Recommendation Report for Planning Permission for Works or Extension to a Dwelling

REF NO: **AW/55/13/**

LOCATION: 2 Queens Fields East
Aldwick

PROPOSAL: Garage extension with new vehicular access (resubmission following
AW/321/12/)

sheet 2 of 2

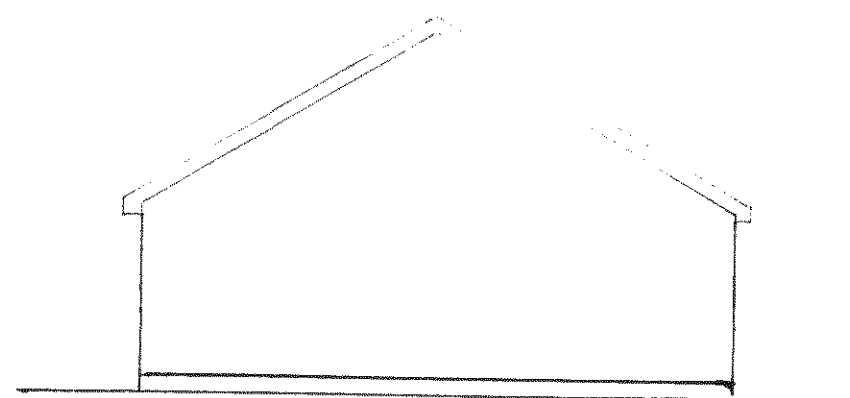
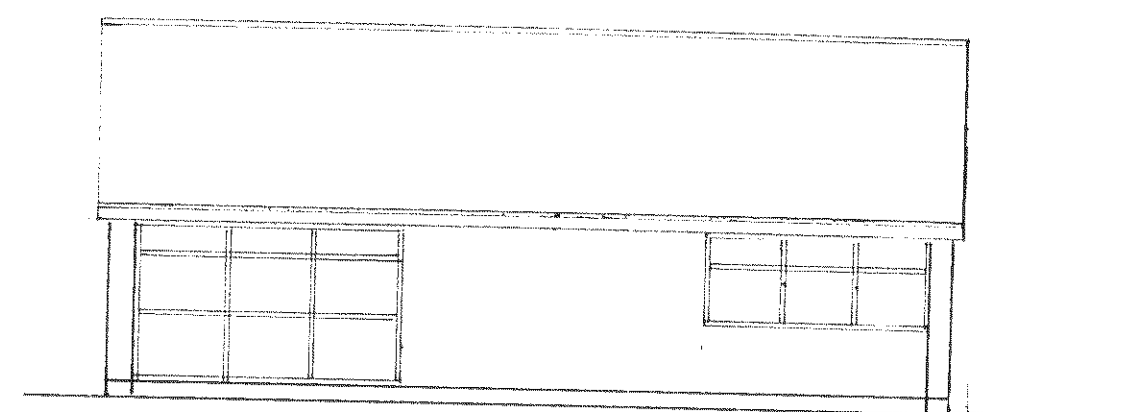
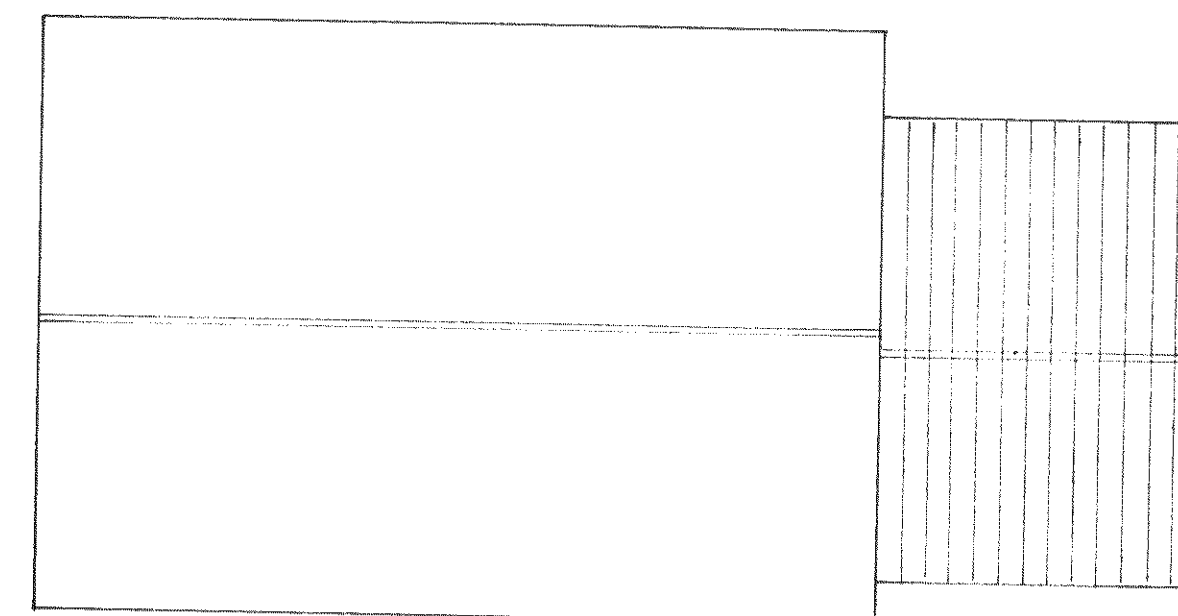
The proposed garage is setback 0.5m from the primary frontage of the dwelling and down 0.5m from the existing main ridge of the dwelling. The proposal is subservient to the existing.

sheet 1 of 2

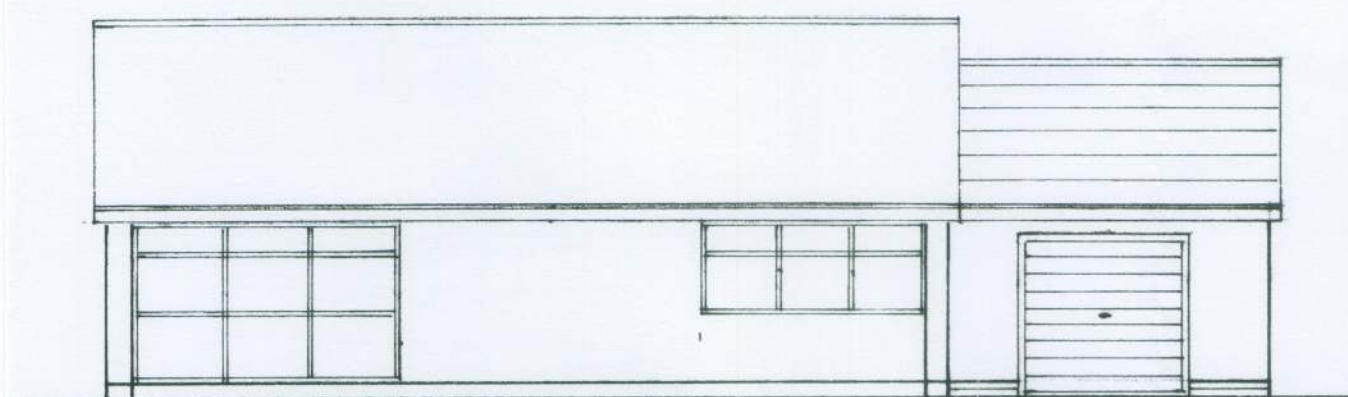
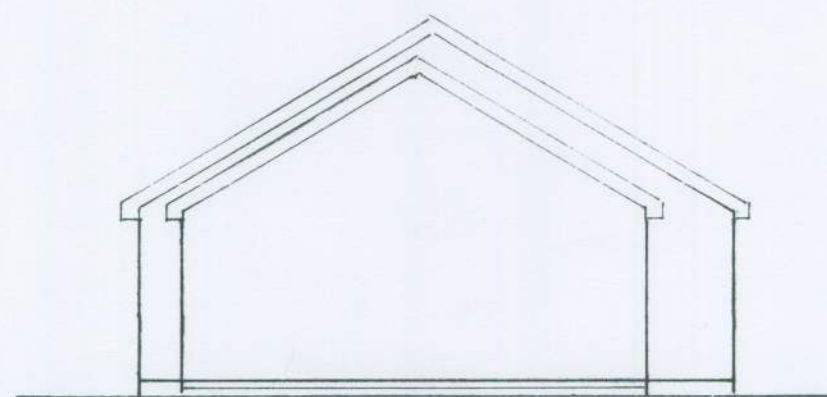
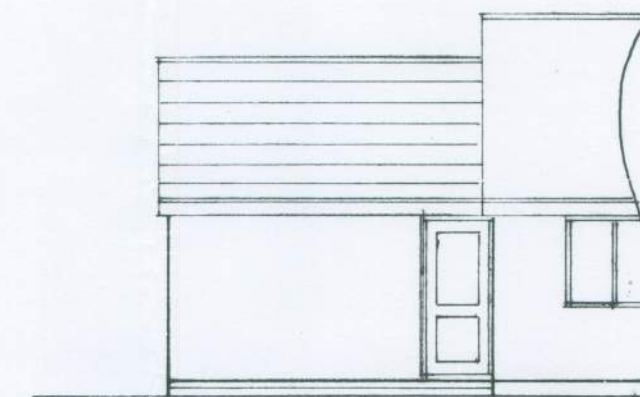
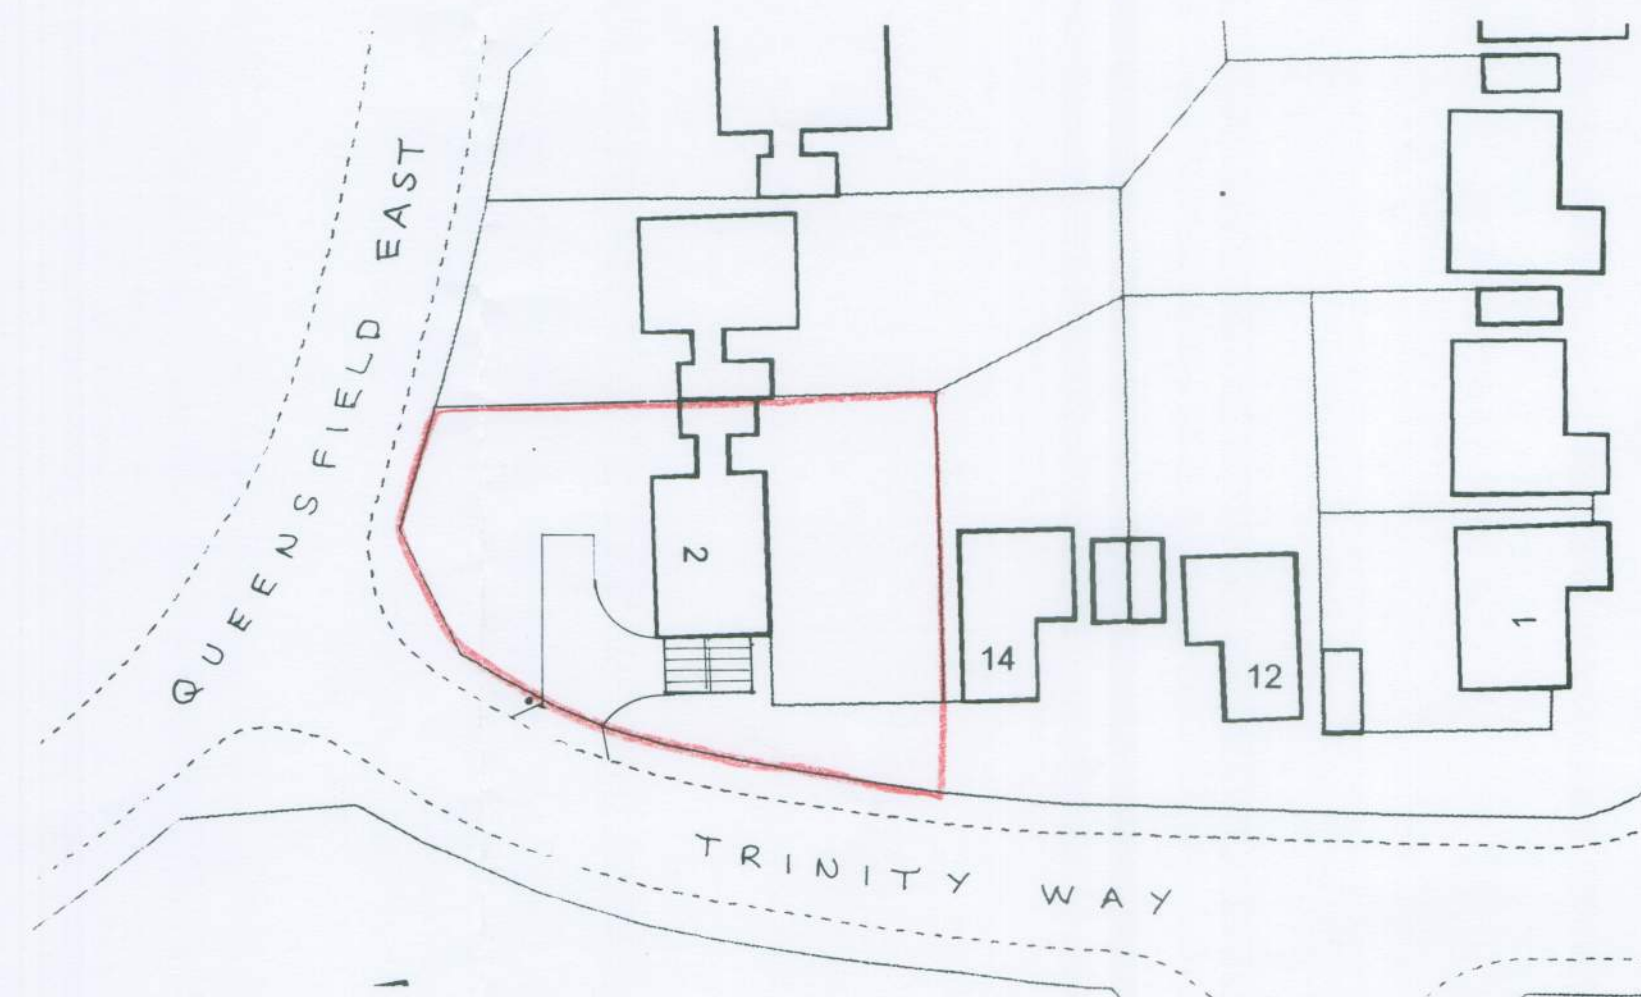
- The location of the access on the corner with turning area will provide good visibility for users of the garage. There are similarly positioned garages and driveways on corners opposite the site.

- Garage is set back 5m from road and will not result in visibility issues.
- Council's Planning Officer has visited the site three times and at no time was the road busy.

The proposed garage is separated from the nearest neighbouring dwelling by 14m and will not result in an adverse overlooking, overshadowing or overbearing impact to any neighbouring property.
